From: Contact Centre (CRM) <contact@ribblevalley.gov.uk>
Sent: 03 March 2023 14:12
To: Planning
Subject: Planning Application Comments - 3/2021/0660, 3/2021/0661 FS-Case-493085652

Planning Application Reference No.: 3/2021/0660, 3/2021/0661

Address of Development: HARP PROJECT

UNITED UTILITIES WATER LIMITED  
HAWESWATER AQUEDUCT RESILIENCE PROGRAMME  
PROPOSED VEHICLE ROUTING  
PAGE 3 OF 4

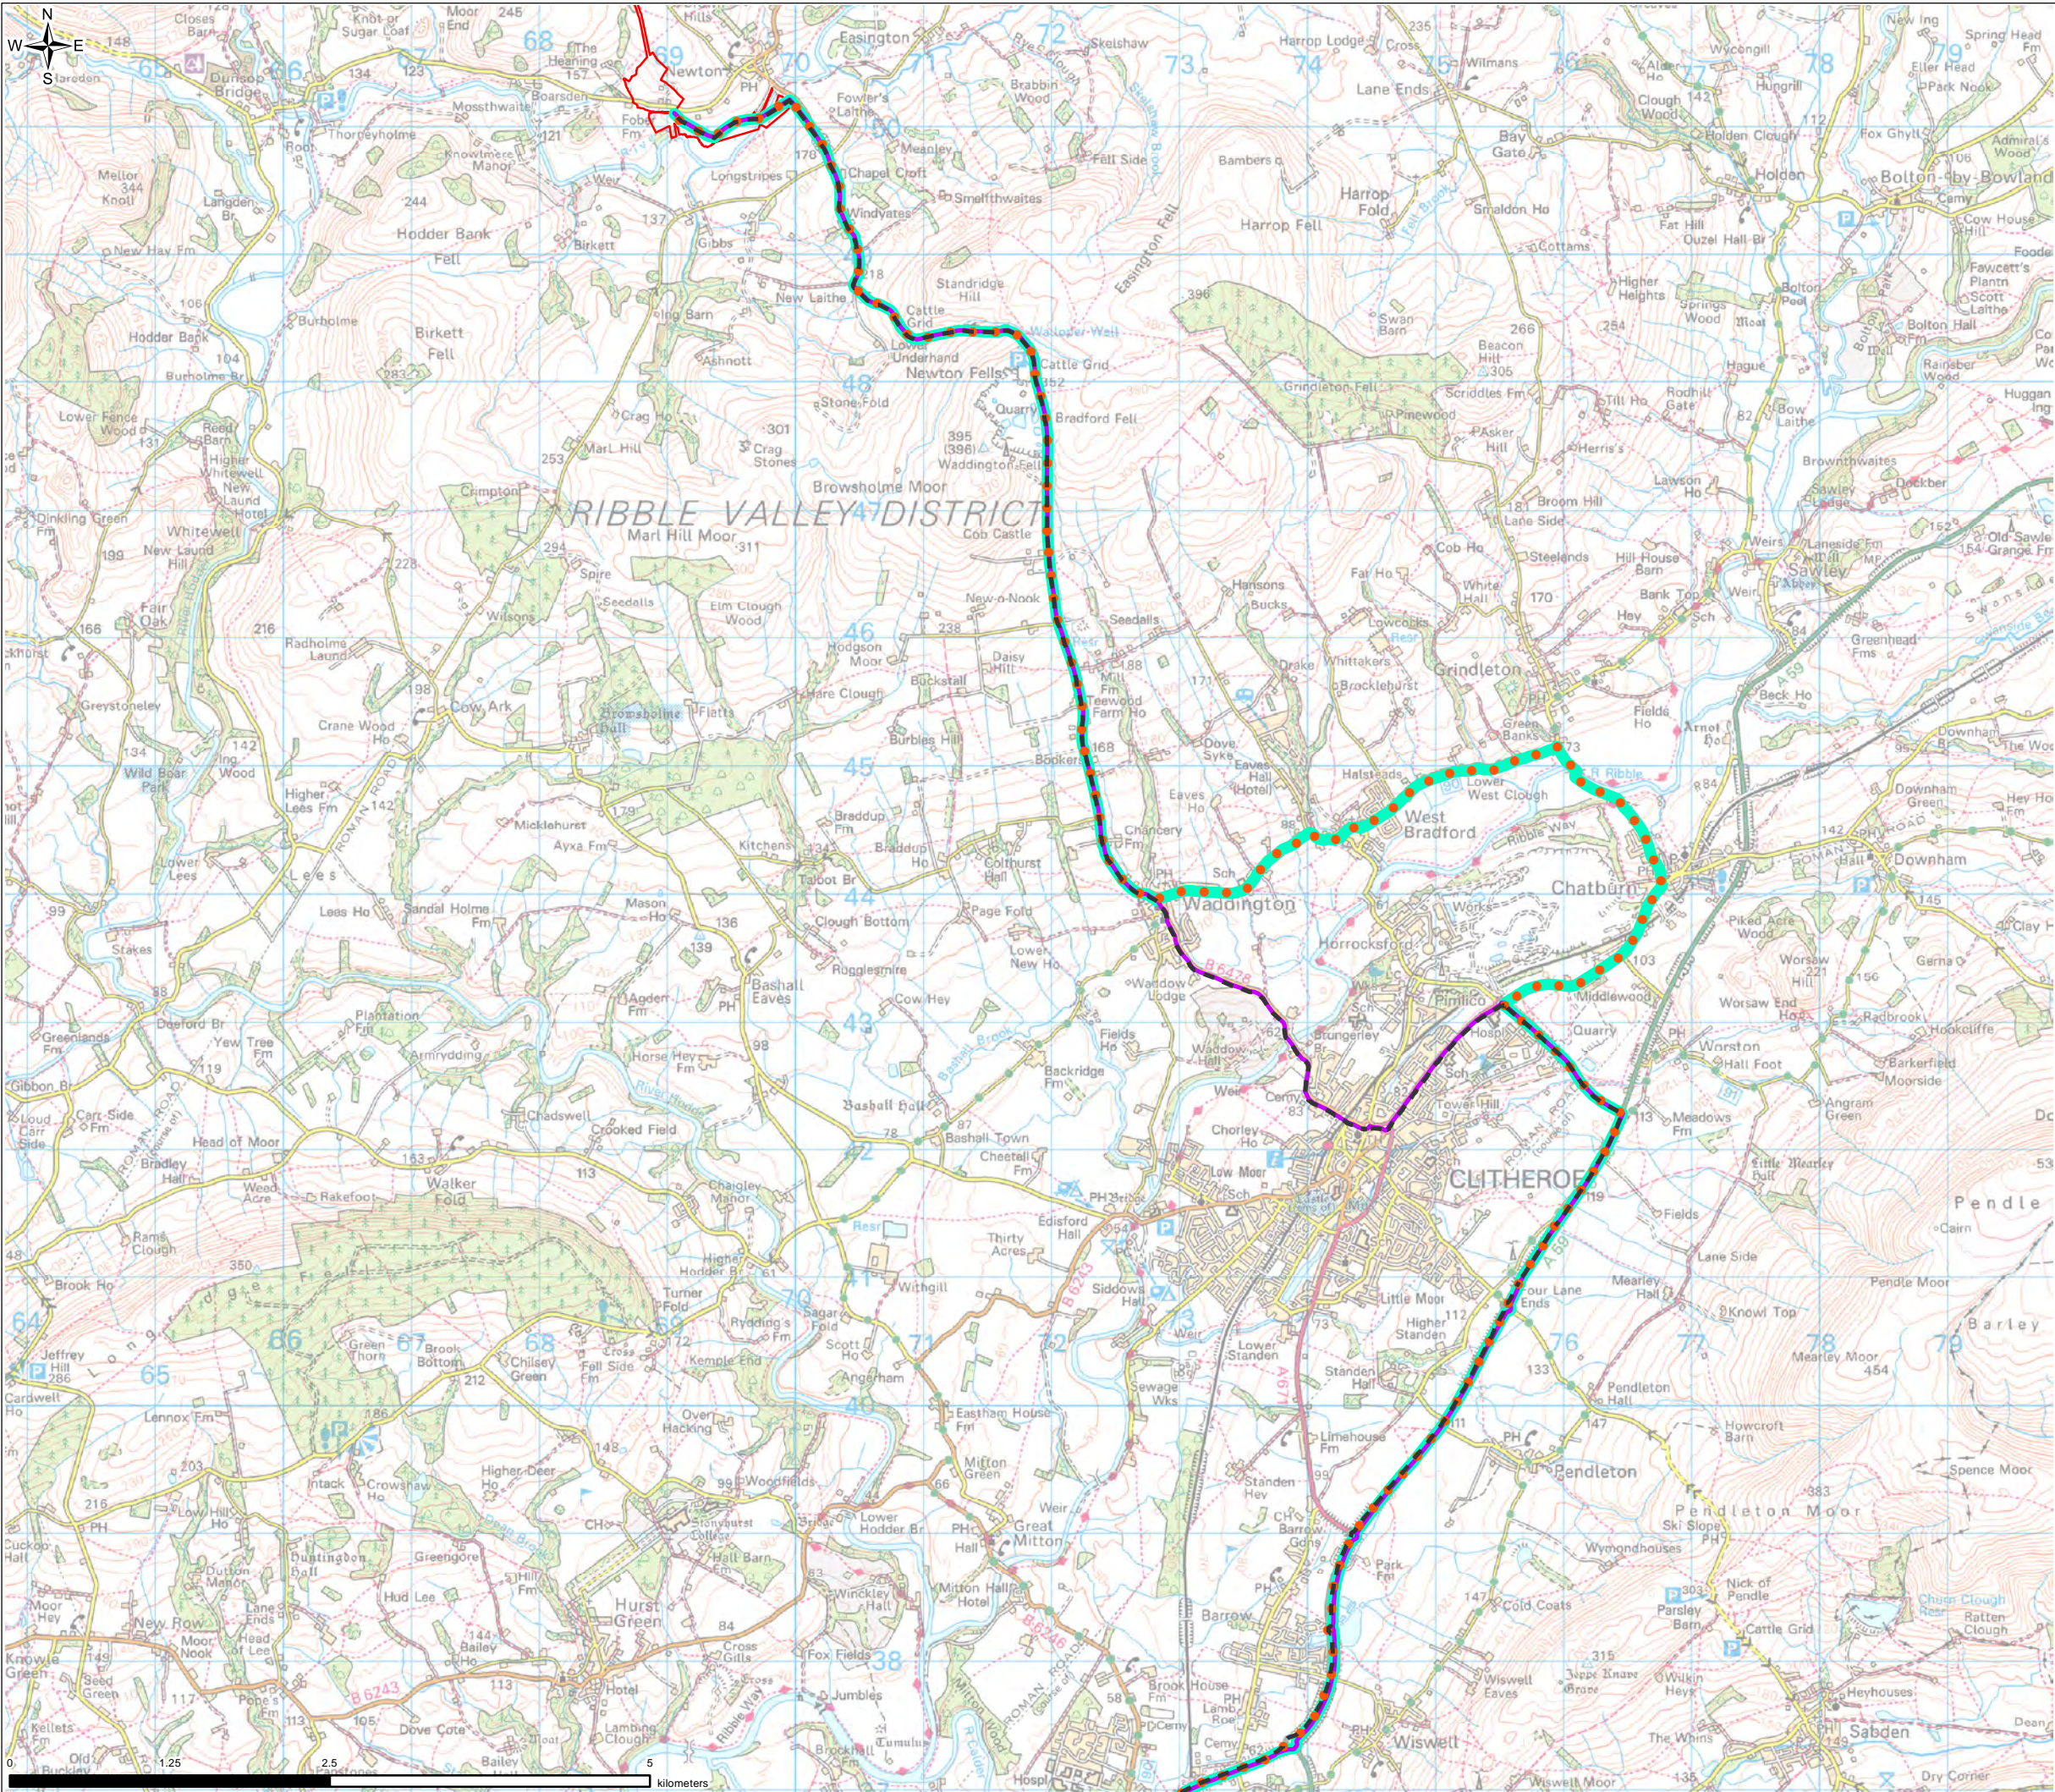
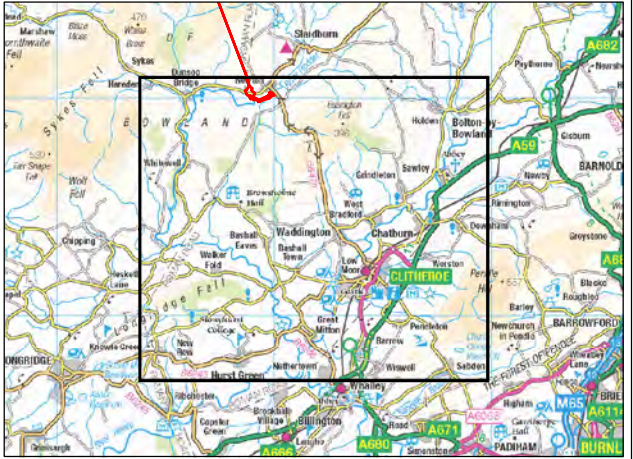
With specific reference to section 1, Haulage Route 1, route 1E through Newton: public meetings re HARP led me to understand that ALL associated traffic would use the new haul road south of the village and I strongly believe that that should be the case. I therefore believe that it is essential that the haul road should be designed and managed to that end and the provision of route 1E abandoned, for the following reasons:-
Route 1E introduces increased air, noise and vibration pollution to the village, increased congestion (there are at least two "pinch points" limiting passage to one vehicle only at a time) and considerable increased risk to the numerous walkers and cyclists who regularly pass through the village - there are narrow roads and no footpaths. I also do not believe that, in practice, the proposed limitations on vehicle numbers, speed limits and permitted times of transit will be adhered to and that the suggested policing/monitoring will not happen, leaving the route open to being abused; the suggested monitoring by the community is adding insult to injury!
